Gatwick Northern Runway

TR020005

National Highways Comments on any Submissions Received by Deadline 6

July 2024

Title
Gatwick Business as Usual (BaU) Signalisation Scheme Concept Design APFP Regulations 5(2)(q) - Sheet 1 Highway Layout Plans - North Terminal

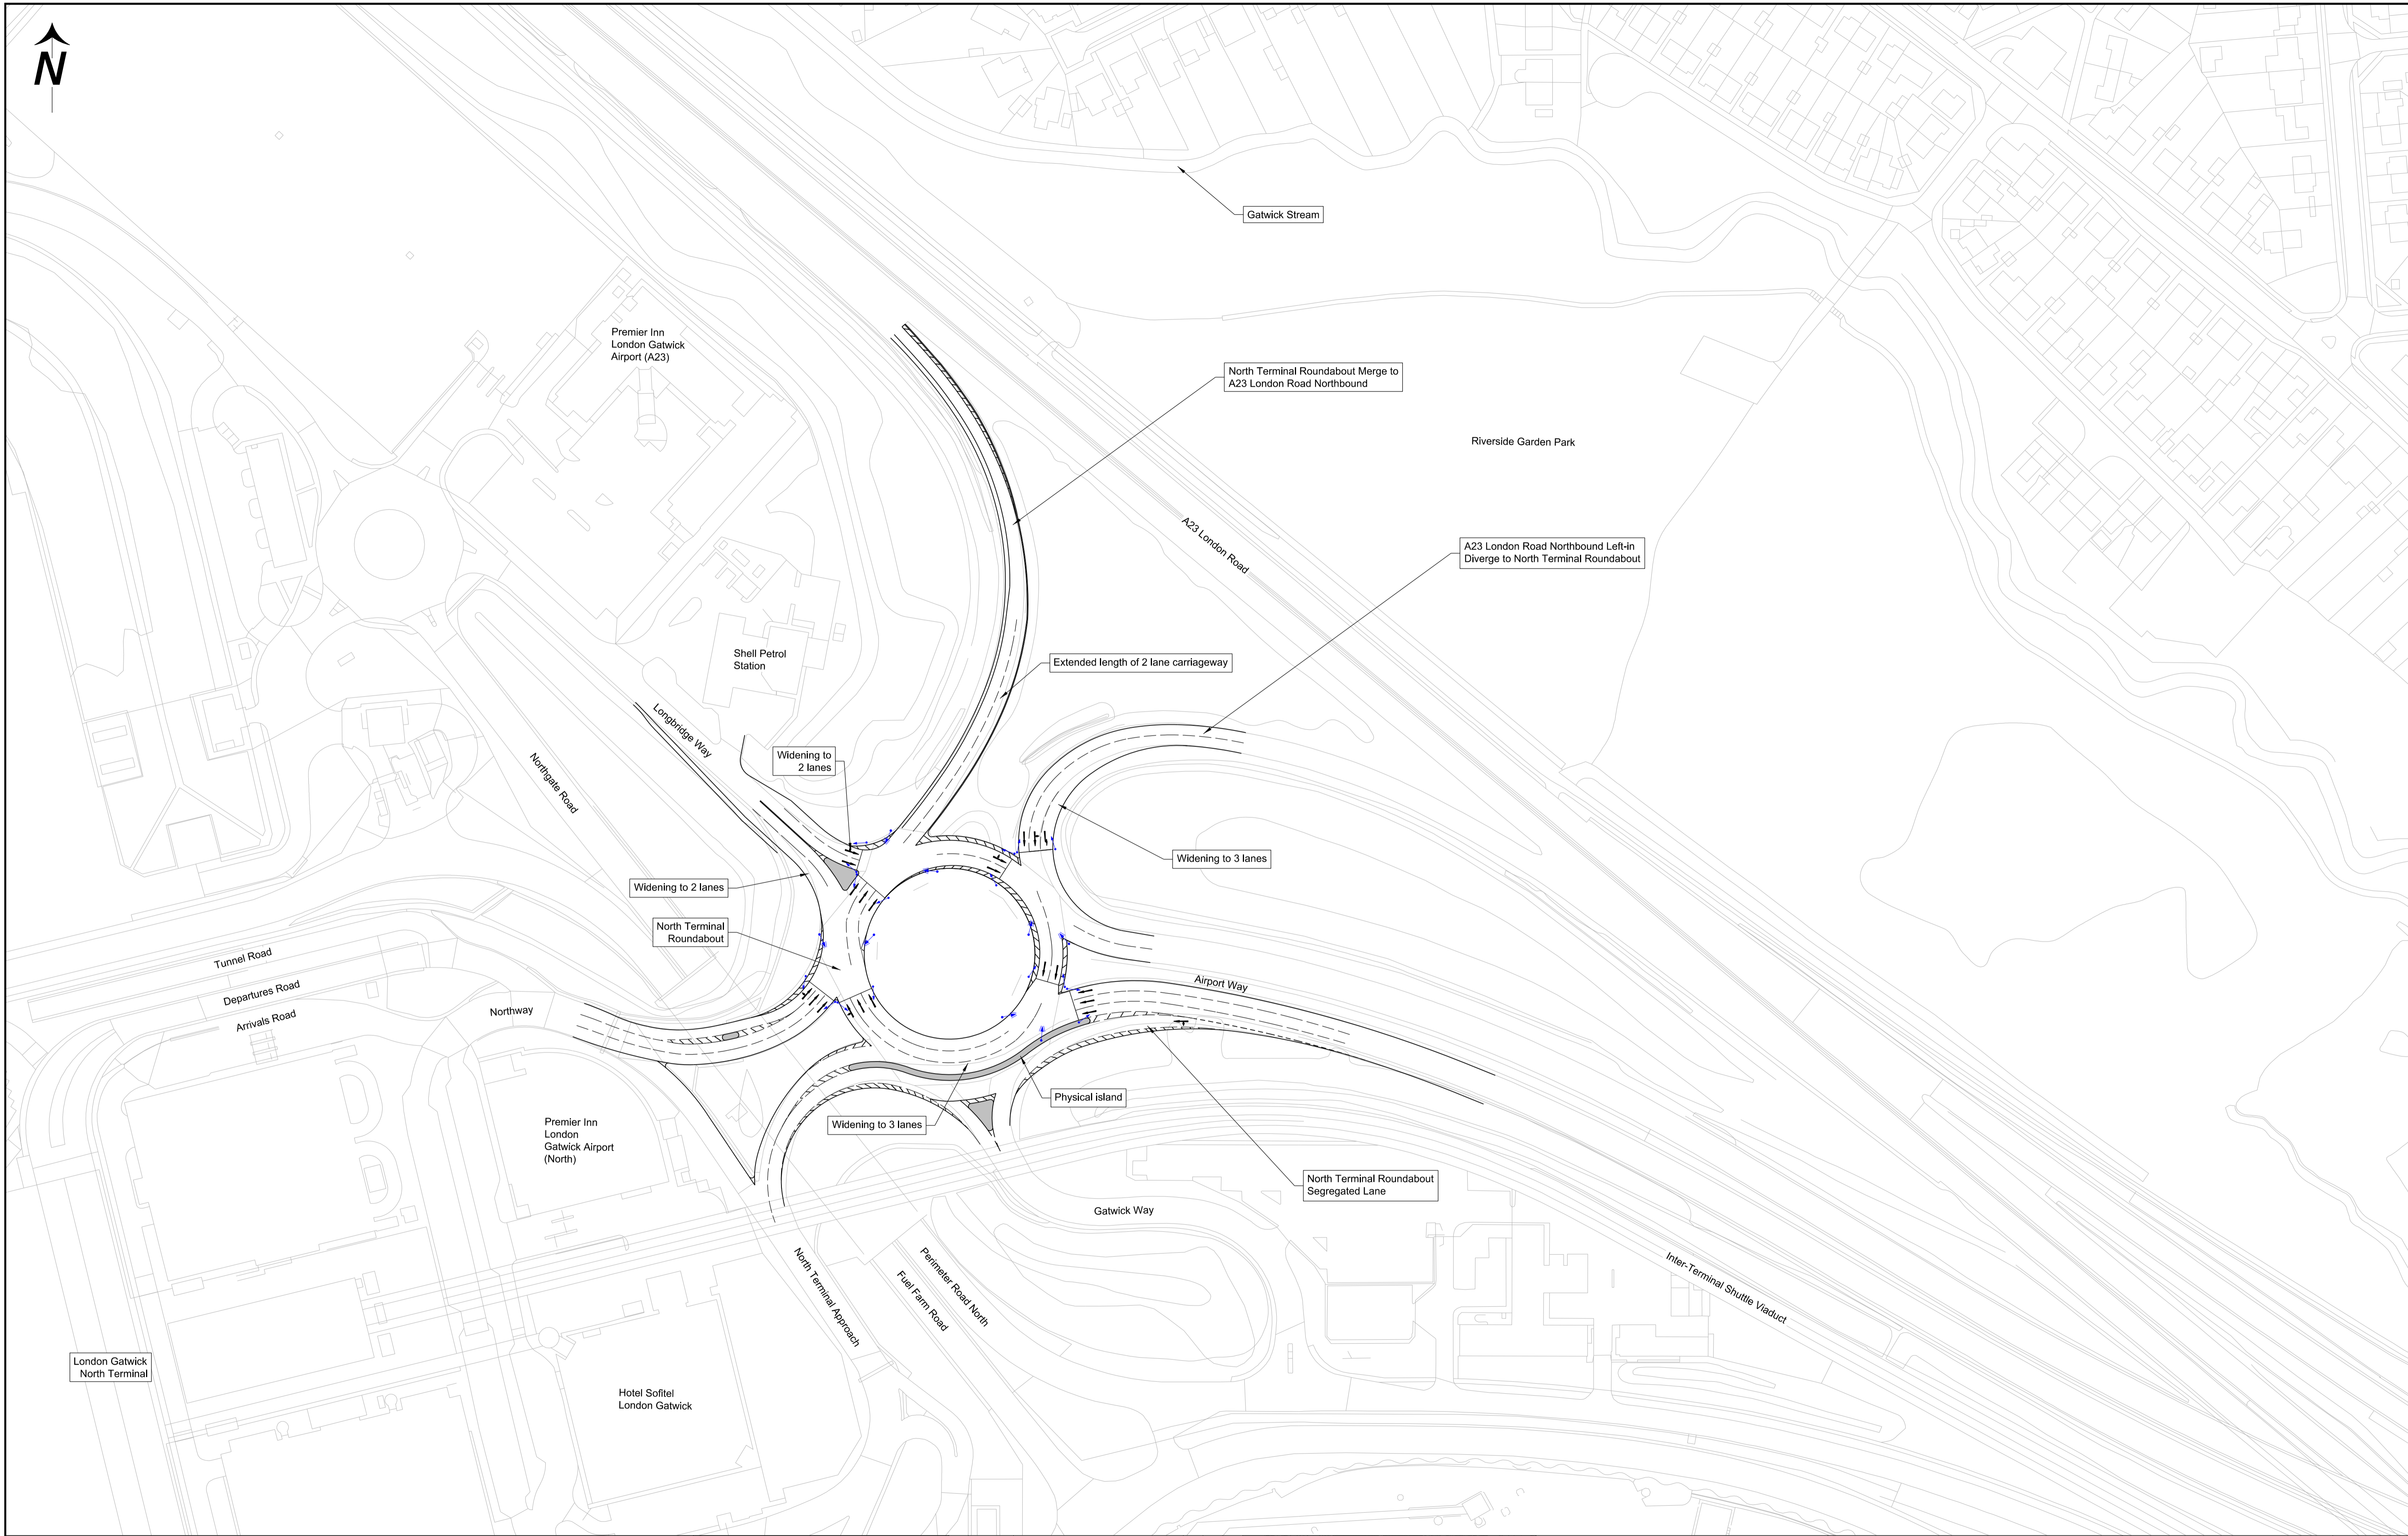
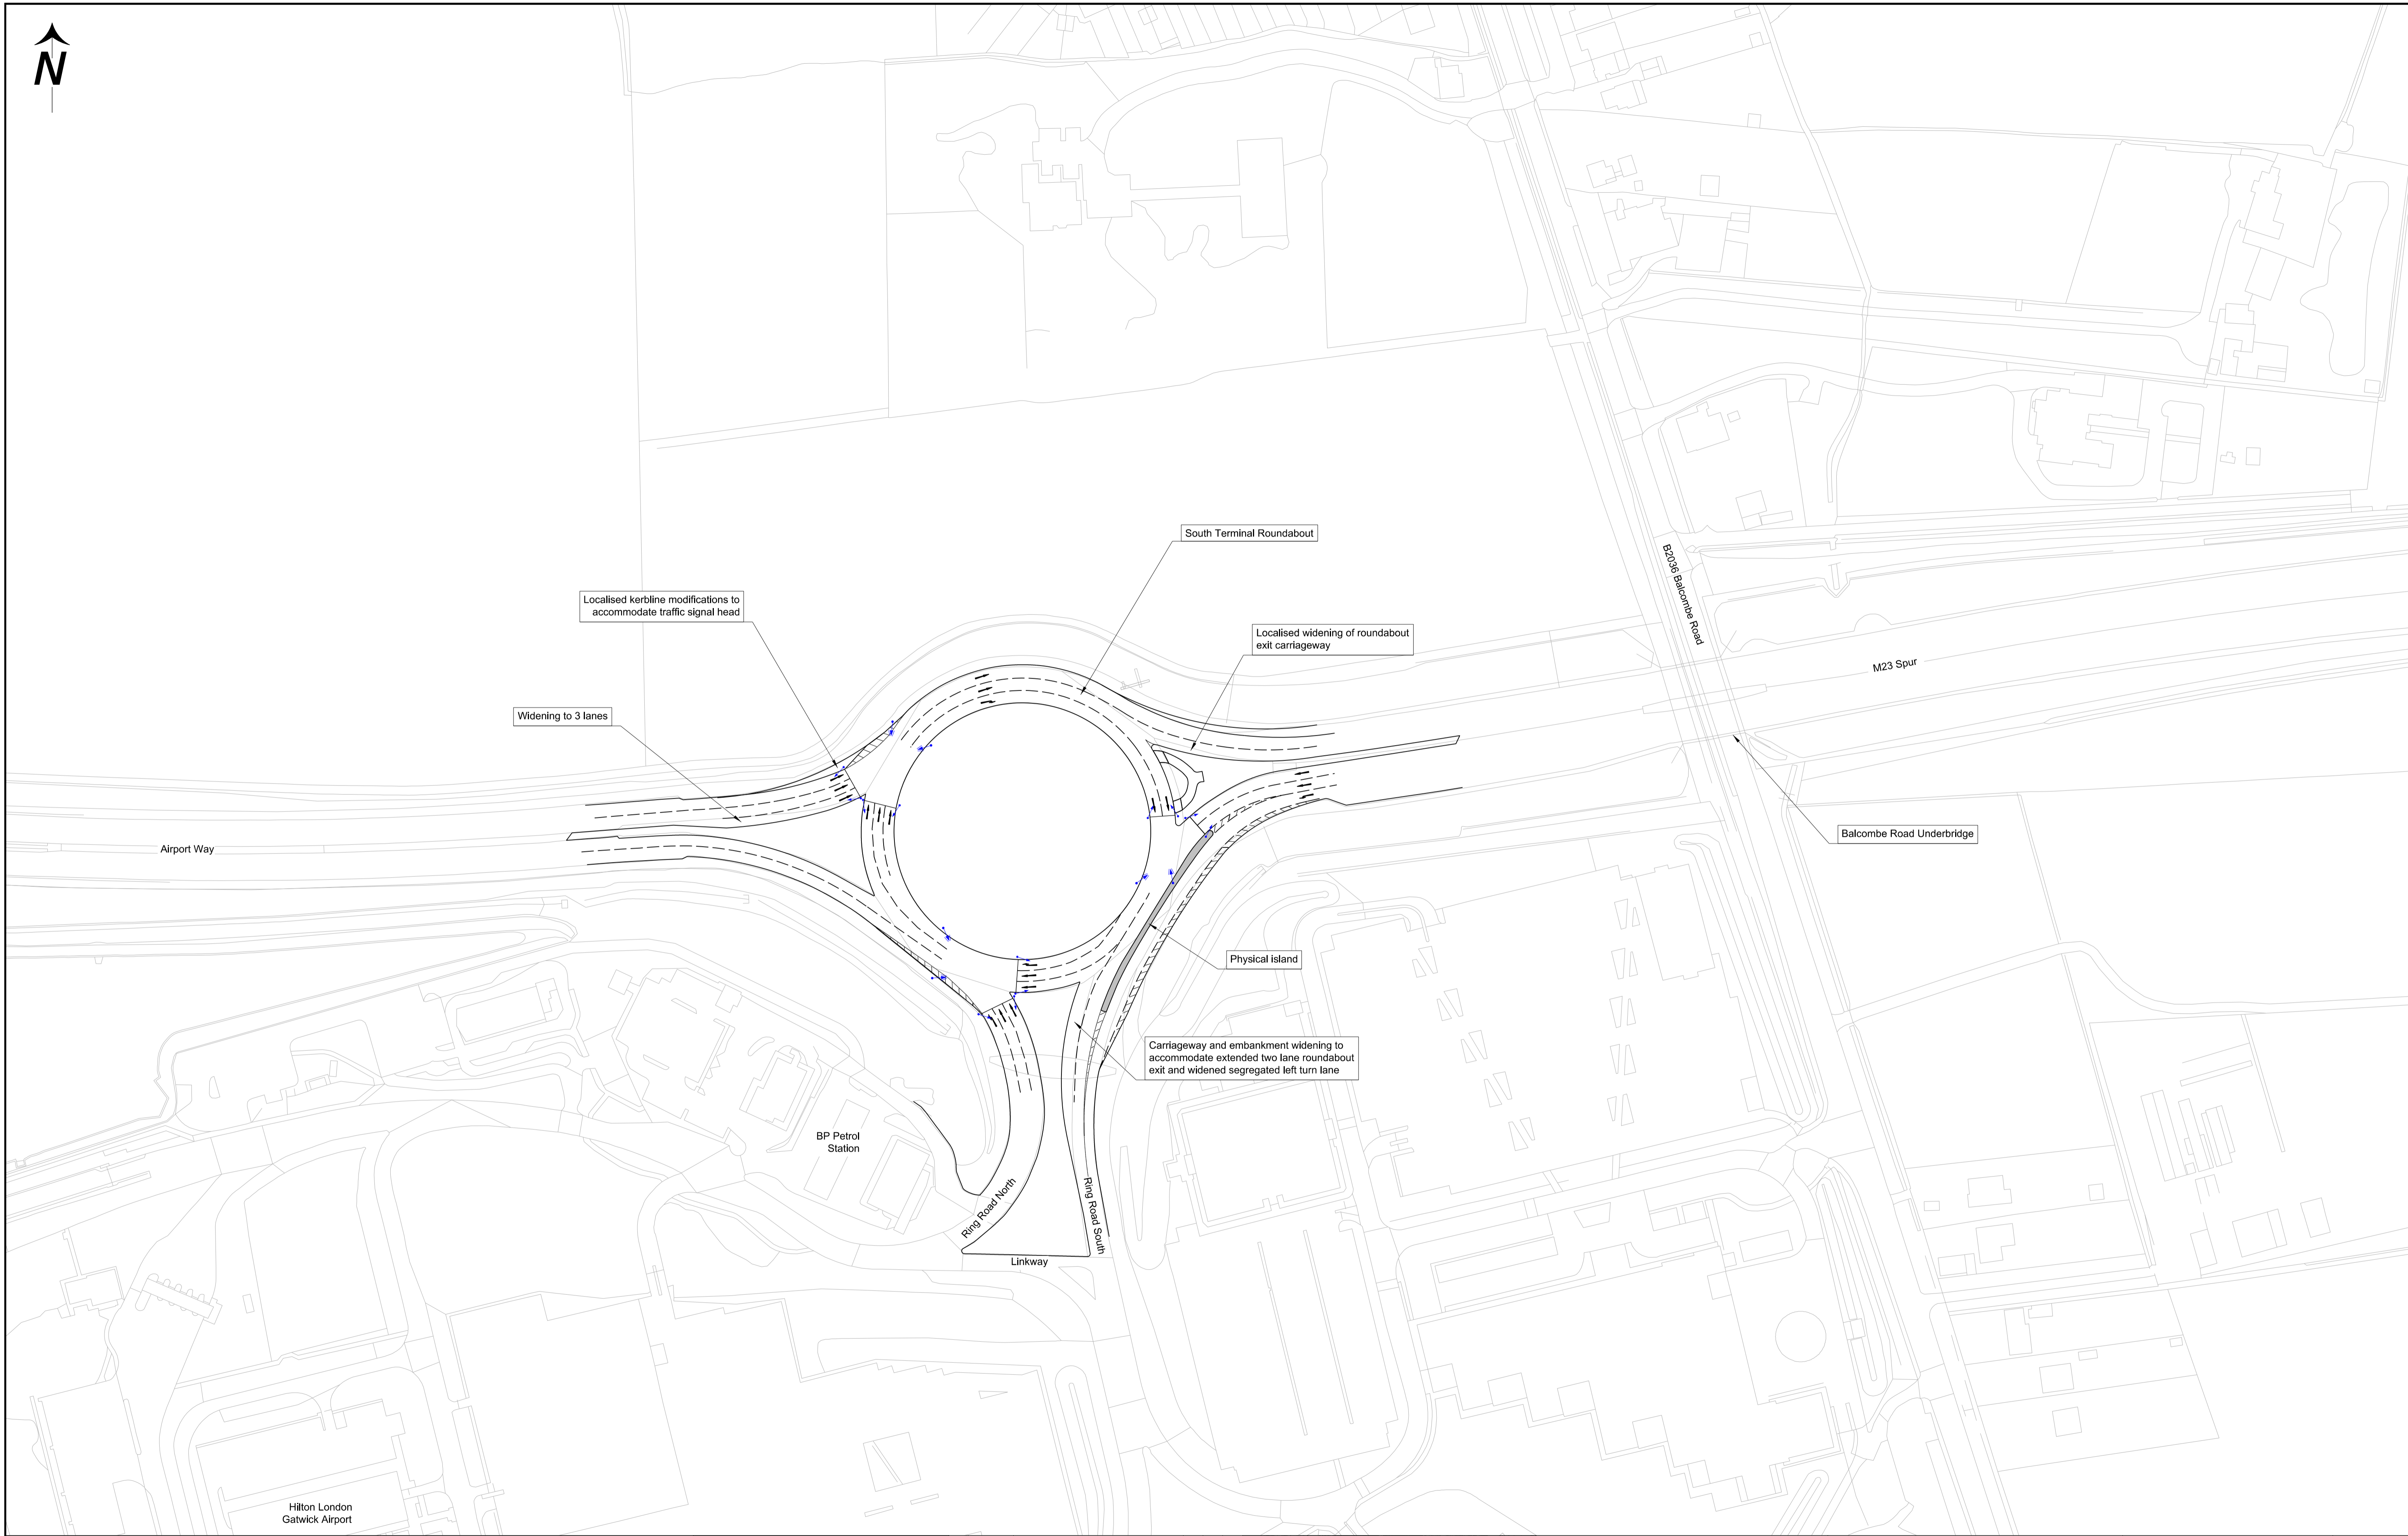
Schedule 2	REP6-005	Requirement 33: North and South Terminal roundabouts BAU improvement scheme	National Highways can confirm, subject to adequate agreement of the Framework Agreement, that the wording of Requirement 33 is agreed and it is now satisfied that the completion of these works (assumed as part of the Applicant's assessments) is secured.
